29 January 2021

Department of Planning, Industry & Environment
4 Parramatta Square
12 Darcy Street
PARRAMATTA NSW 2150

Hills of Gold Wind Farm (SSD-9679) - Environmental Impact Statement

F3-1

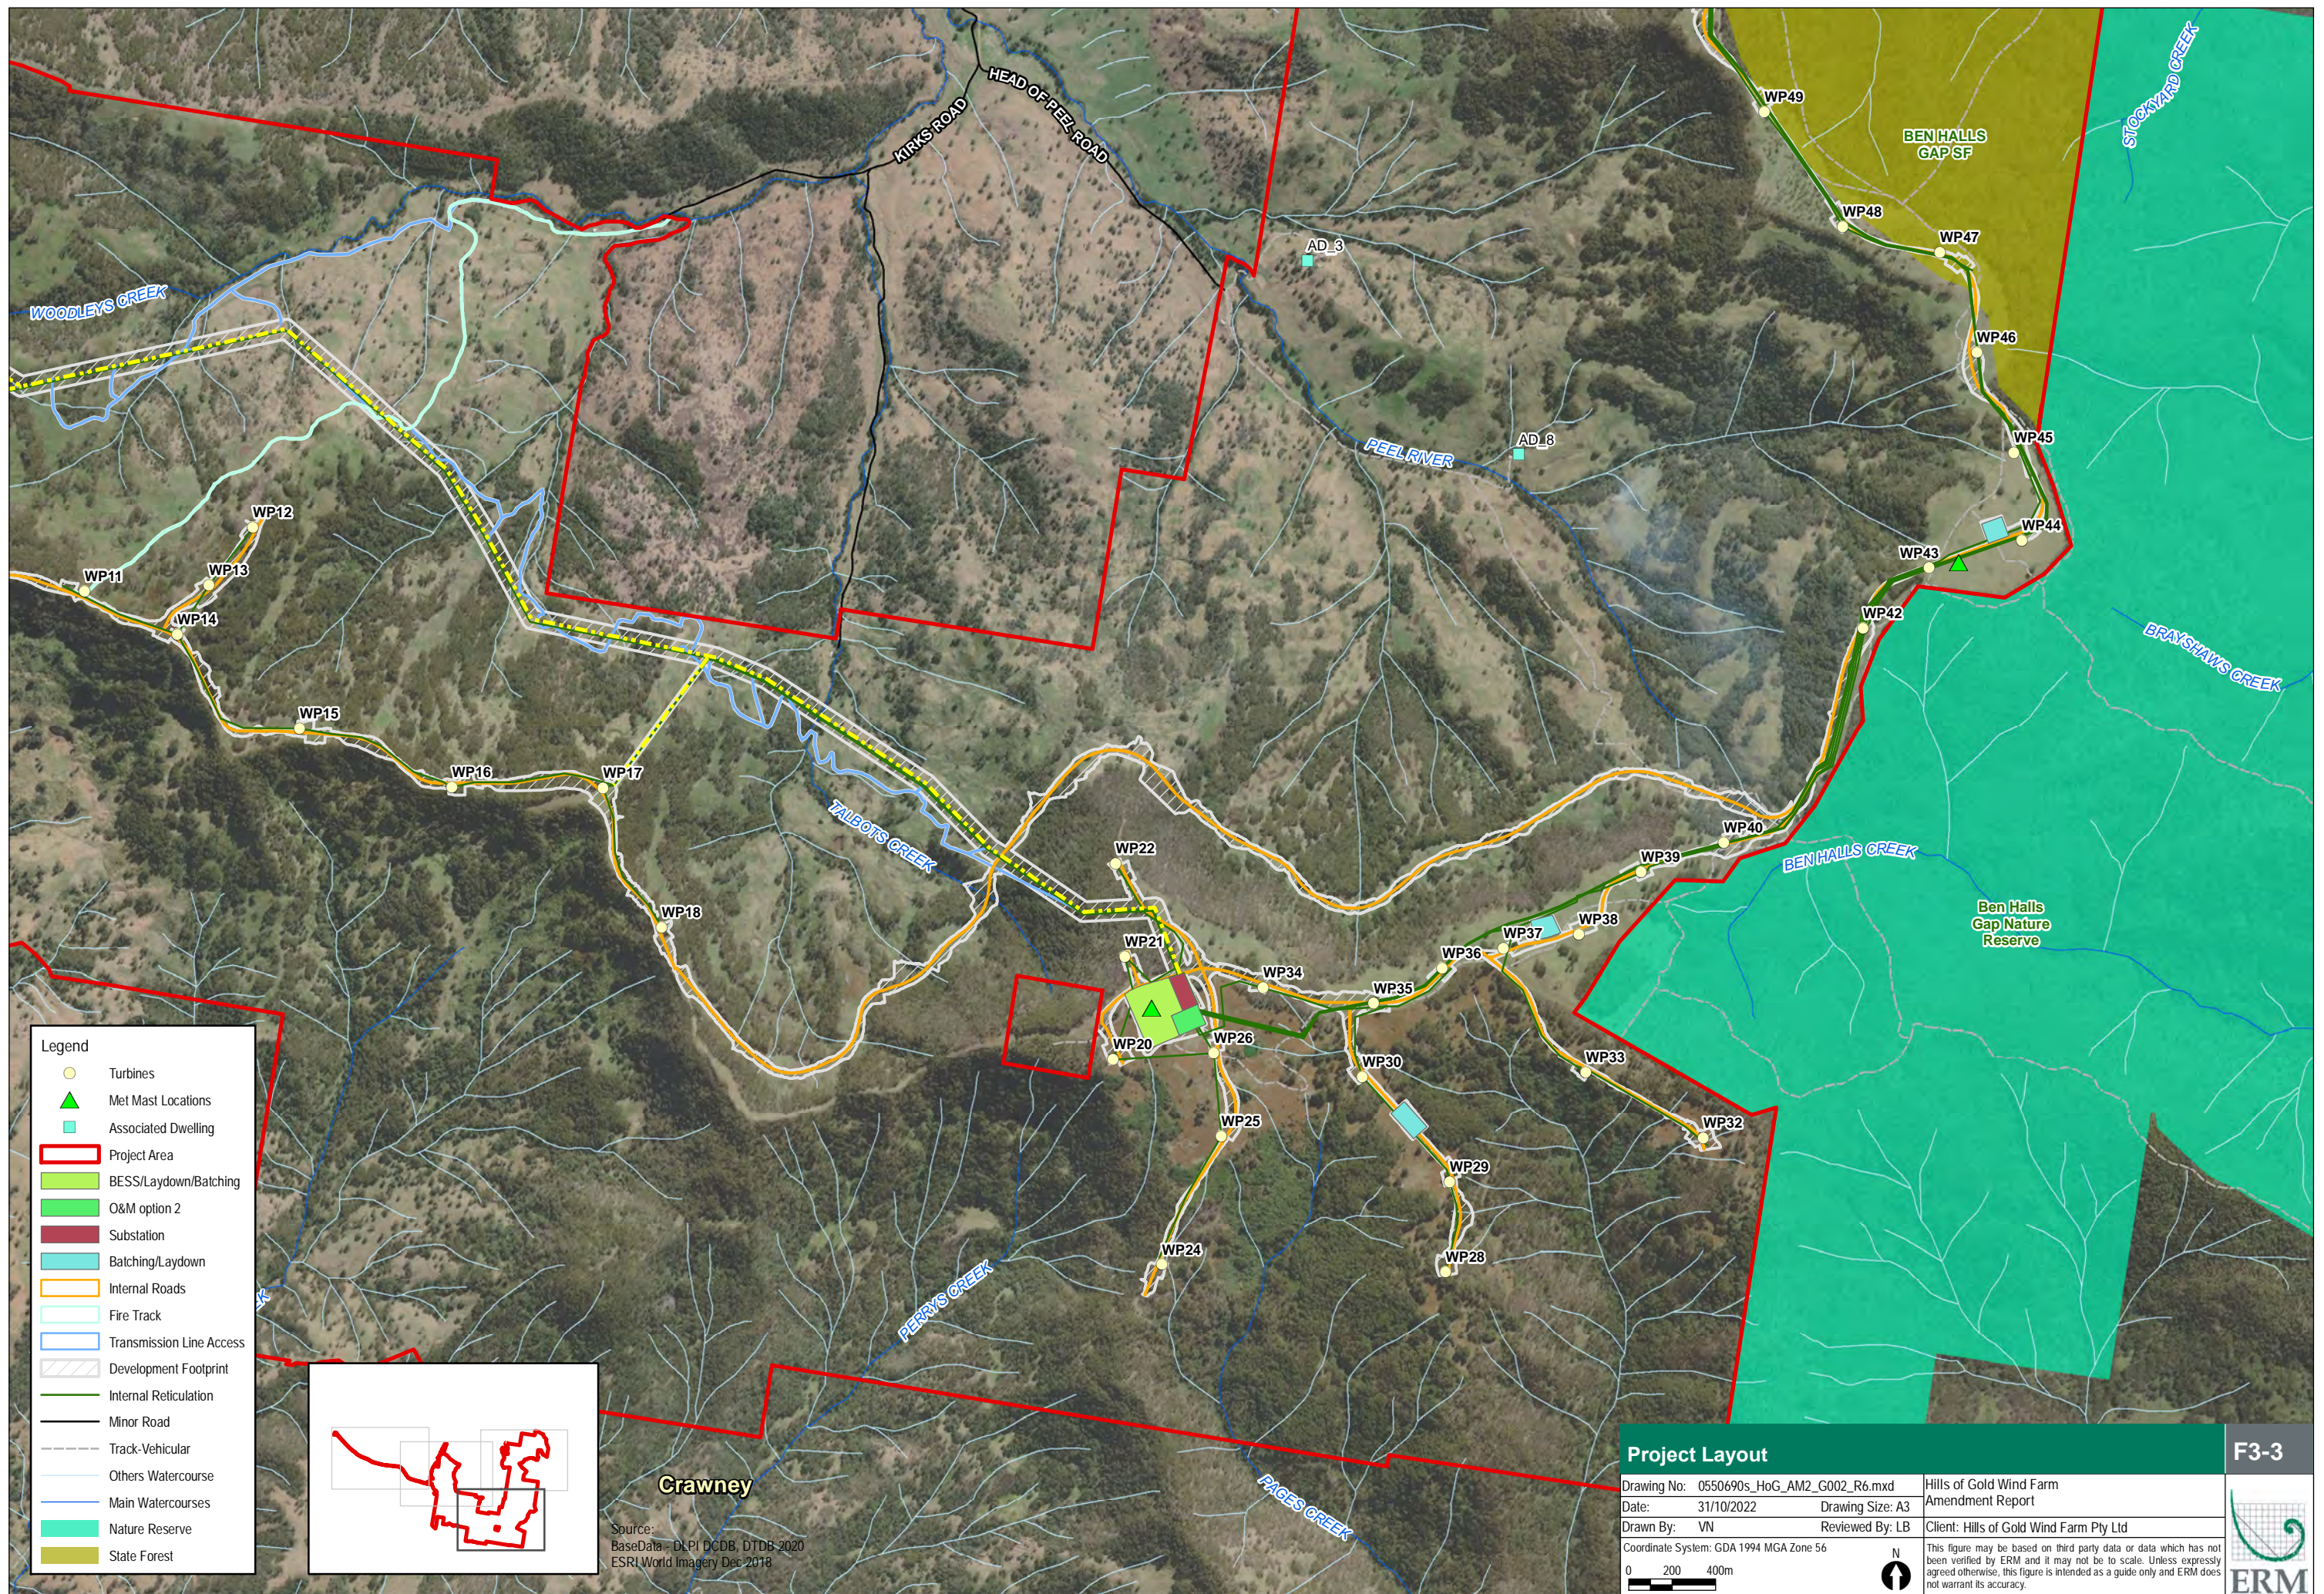
A review of the visual impact assessment raises some concerns in relation to the visual impacts of the wind farm on properties within the Upper Hunter Shire LGA. The proposed wind turbines are densely spaced along the ridgeline forming the LGA boundary and will be highly visible from a number of properties. Consideration should be given to reducing the number of turbines and/or increasing the spacing of the turbines in areas where they are highly concentrated (eg. WP20 – WP39) to mitigate the potential visual impact.
